**APPLICATION BY MORGAN OFFSHORE WIND LIMITED AND  
MORECAMBE OFFSHORE WINDFARM LIMITED FOR A  
DEVELOPMENT CONSENT ORDER FOR THE MORGAN AND  
MORECAMBE OFFSHORE WIND FARMS TRANSMISSION ASSETS  
DEADLINE 6 SUBMISSION BY LANCASHIRE COUNTY COUNCIL**

**22<sup>nd</sup> OCTOBER 2025**

- 5.3. Although the wording of the Outline Public Rights of Way (PRow) Management Plan (F05) (Rep5a-034) has been improved, the following are to be addressed for the item to be approved.

Figure 1.1: Illustrative diagram of a managed crossing of a PRow (1)

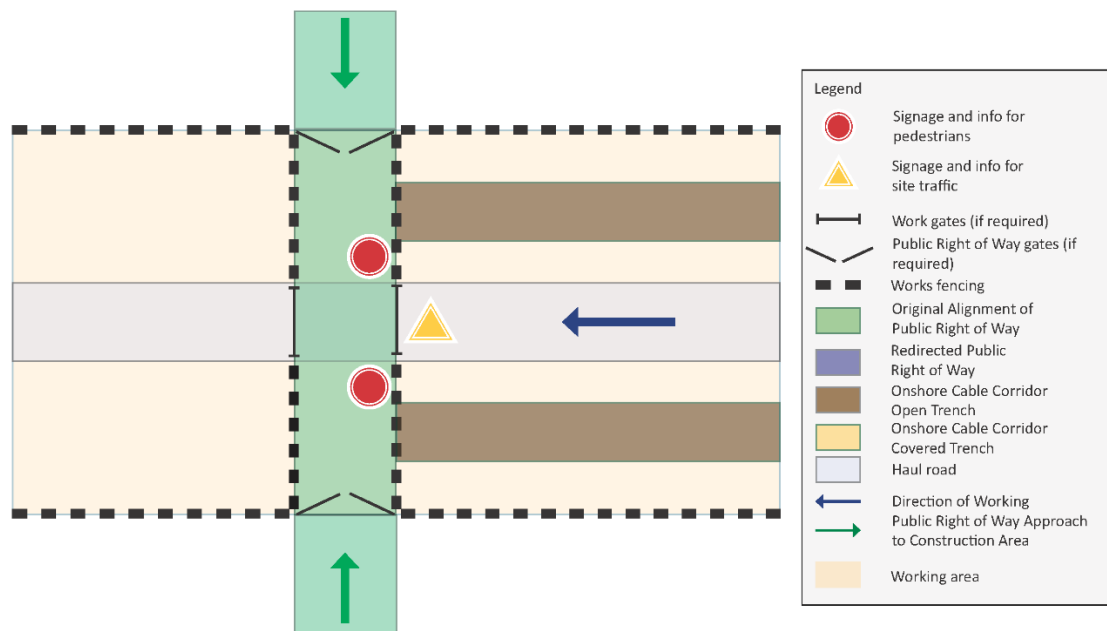
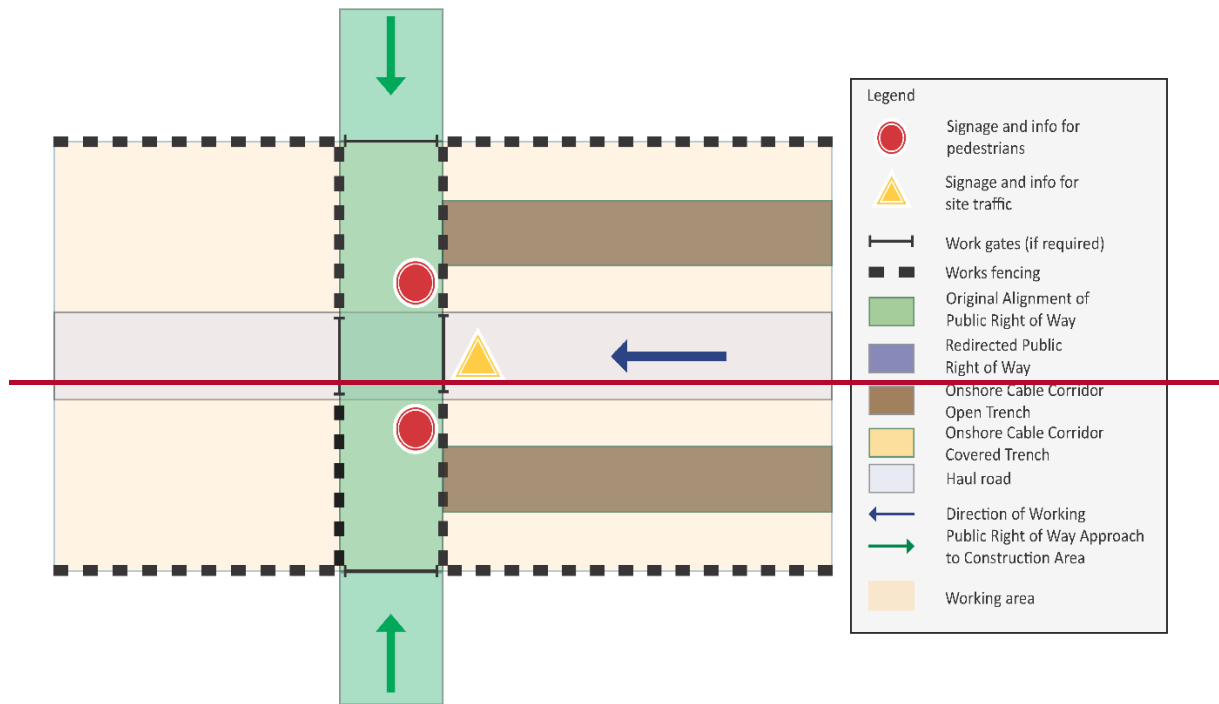
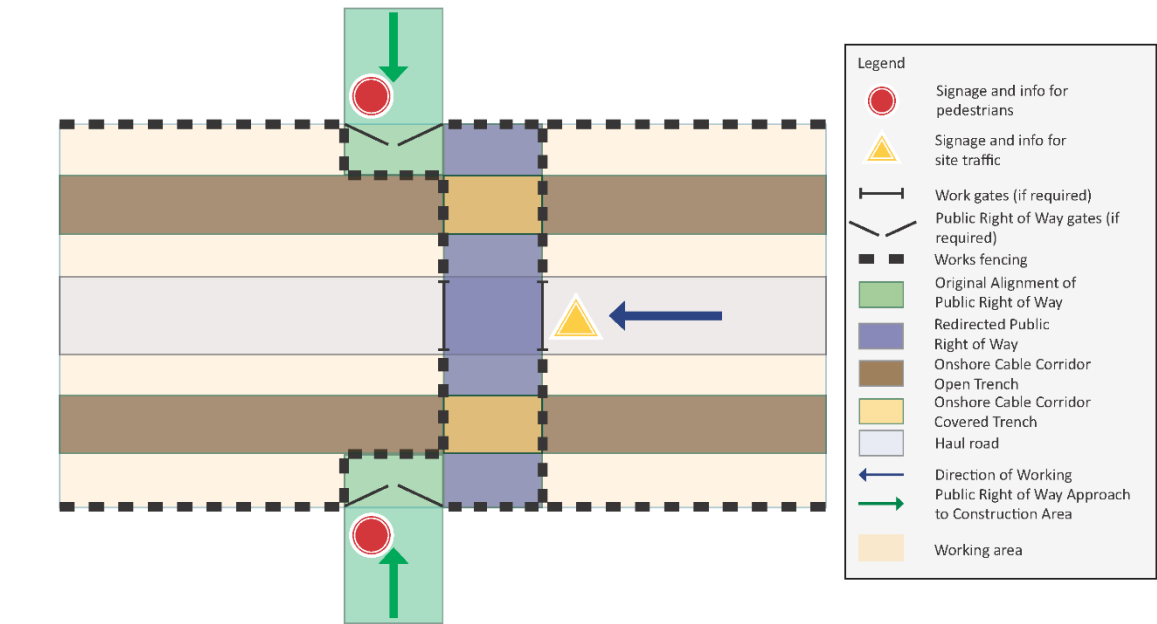
- 5.5. Figures 1.1, 1.2 and 1.3 include gates across the line of the PRow – gates that would restrict 24/7 access along the diverted route are not supported. The general arrangement figures should exclude the inclusion of any limitation across the diverted public path, providing unrestricted passage. This is not to say there may not be a situation necessitating the inclusion of a limitation, for example a self-closing pedestrian either with or without a meshed hoop to BS 5709:2018 standards, however this would be the exception rather than the rule. The reference to gates other than for stock control should be removed throughout the document.

**Figure 1.10: Outline management of PROW within the Onshore Order Limits (Sheet 7)**

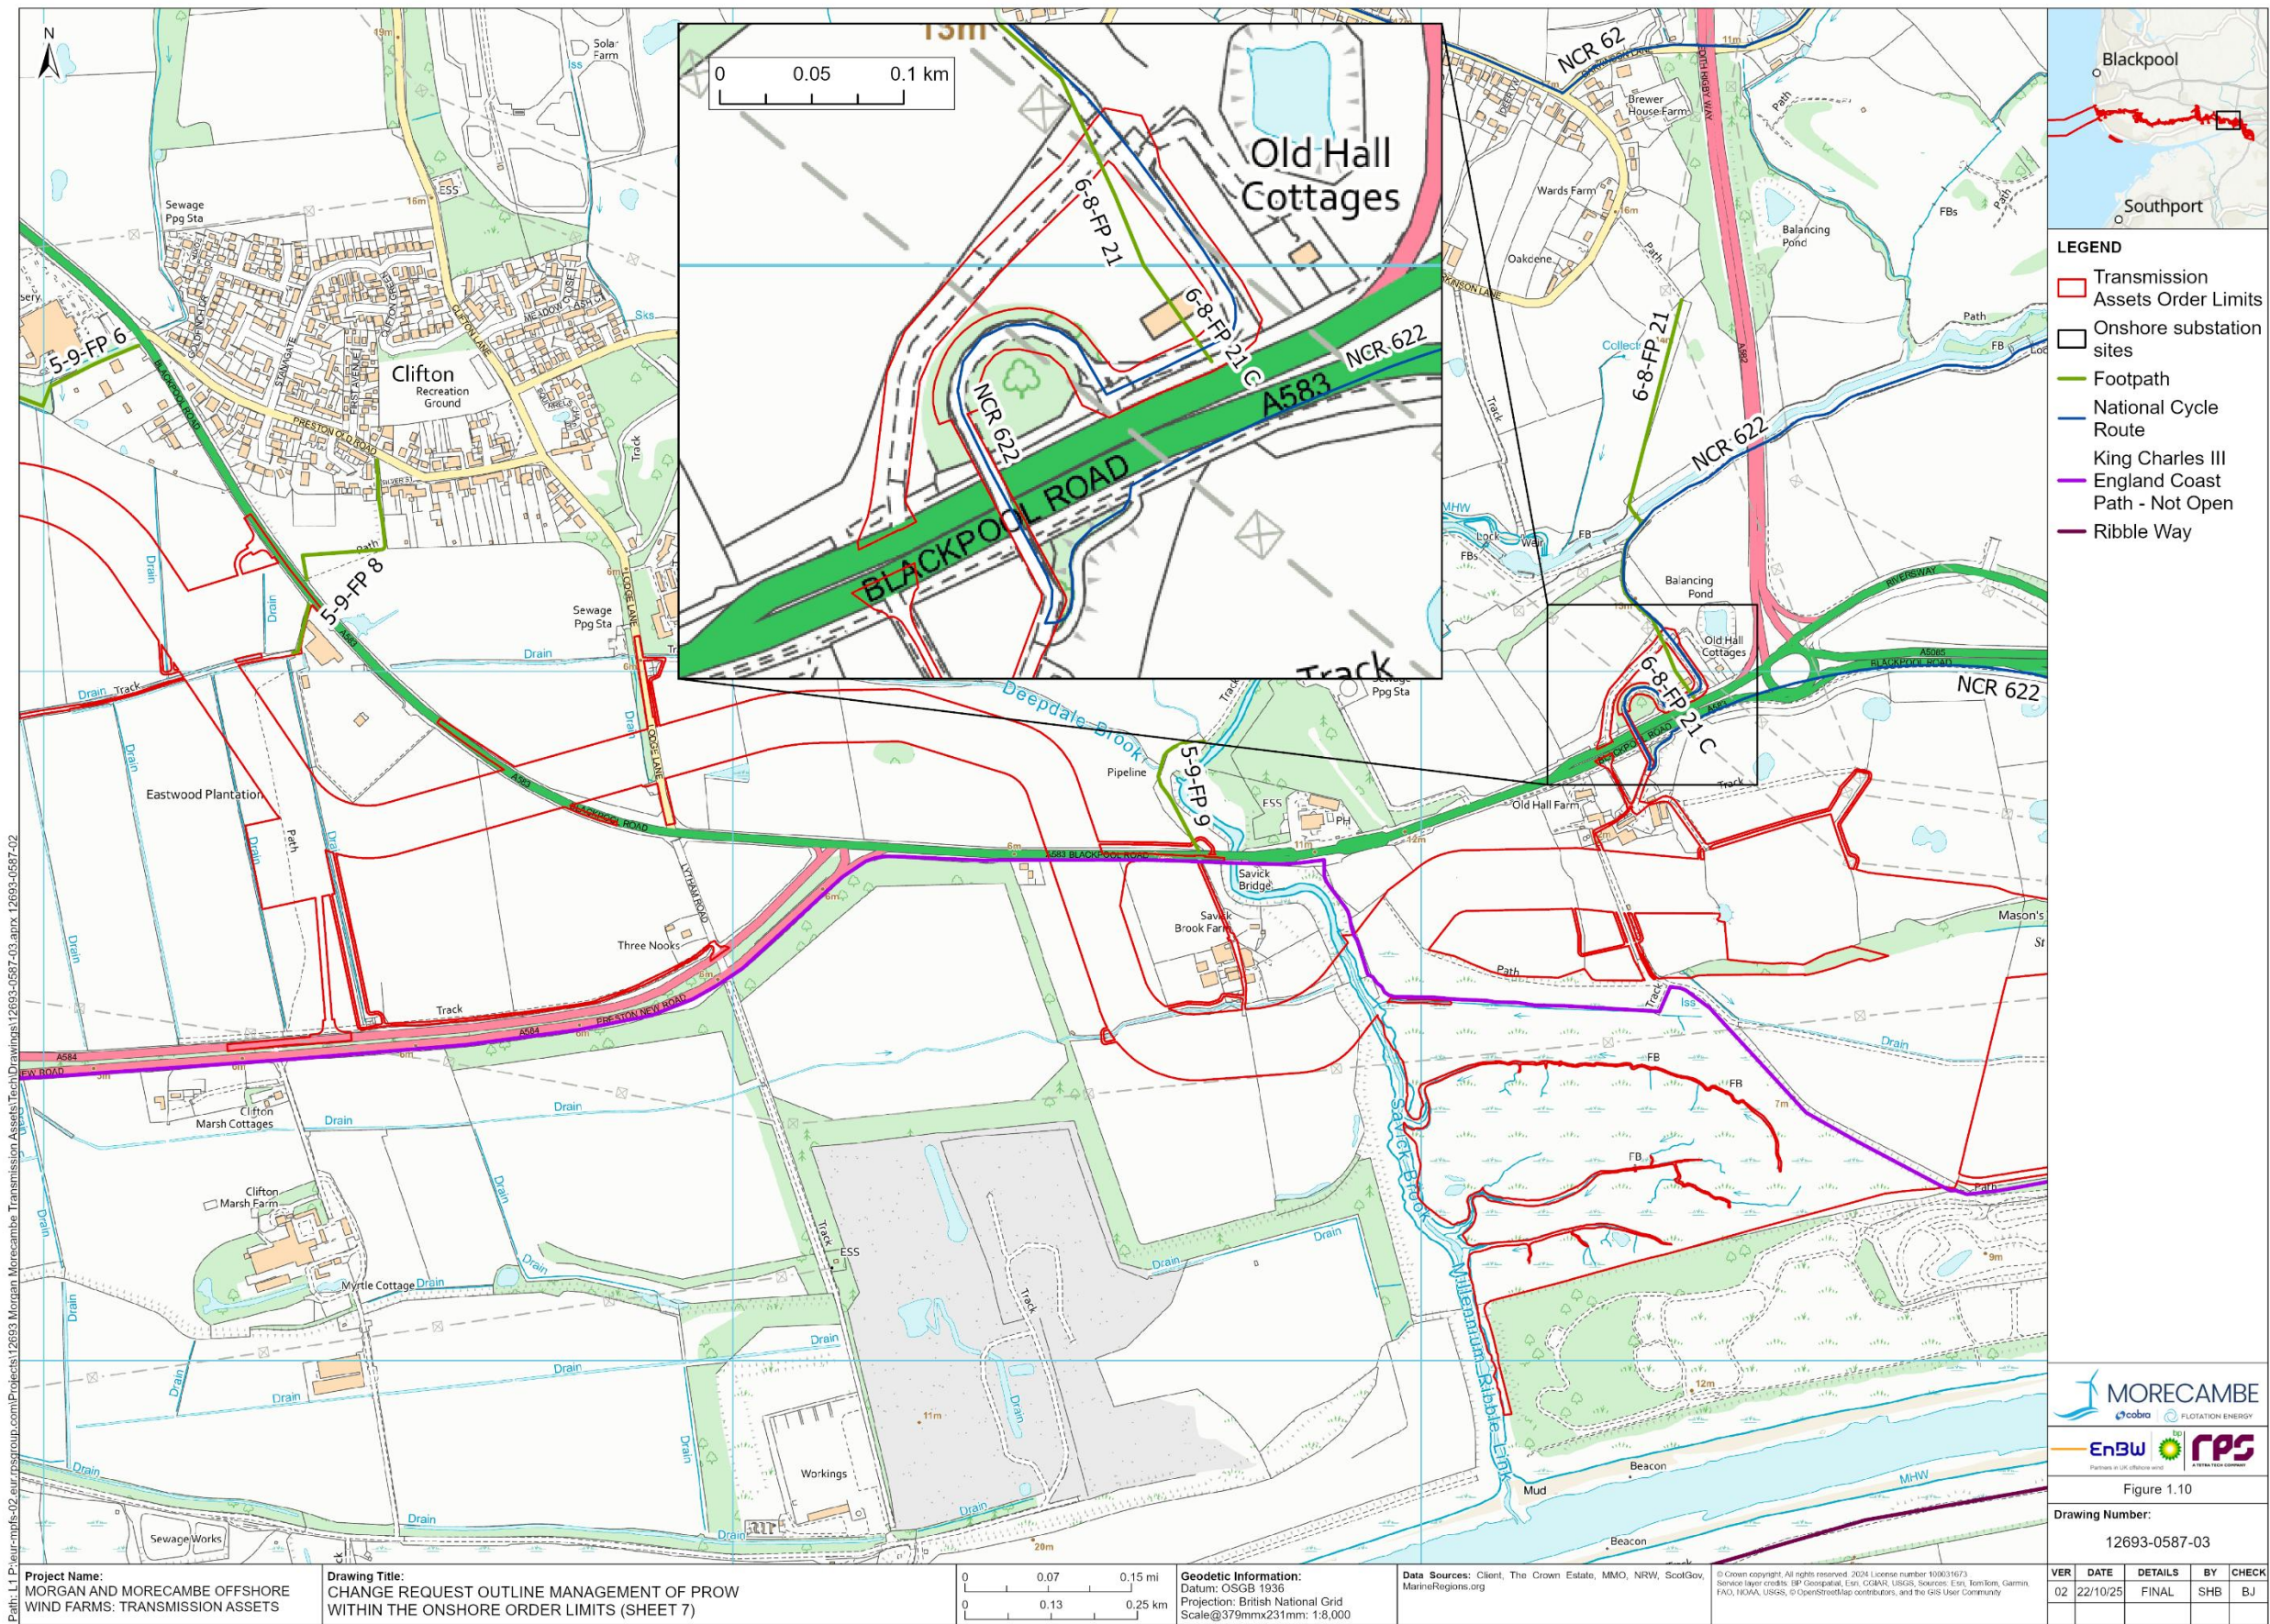
- 5.6. Access 57 via the use of the Guild Wheel and footpath FP0608021 at Lea has been removed although the route remains within Figure 1.10.
- 5.7. No agreement has been reached with regard the use of Bridleway BW0502016/Anna's Road as part of the access track, as such the inclusion of its diversion within the document is not supported at this time.
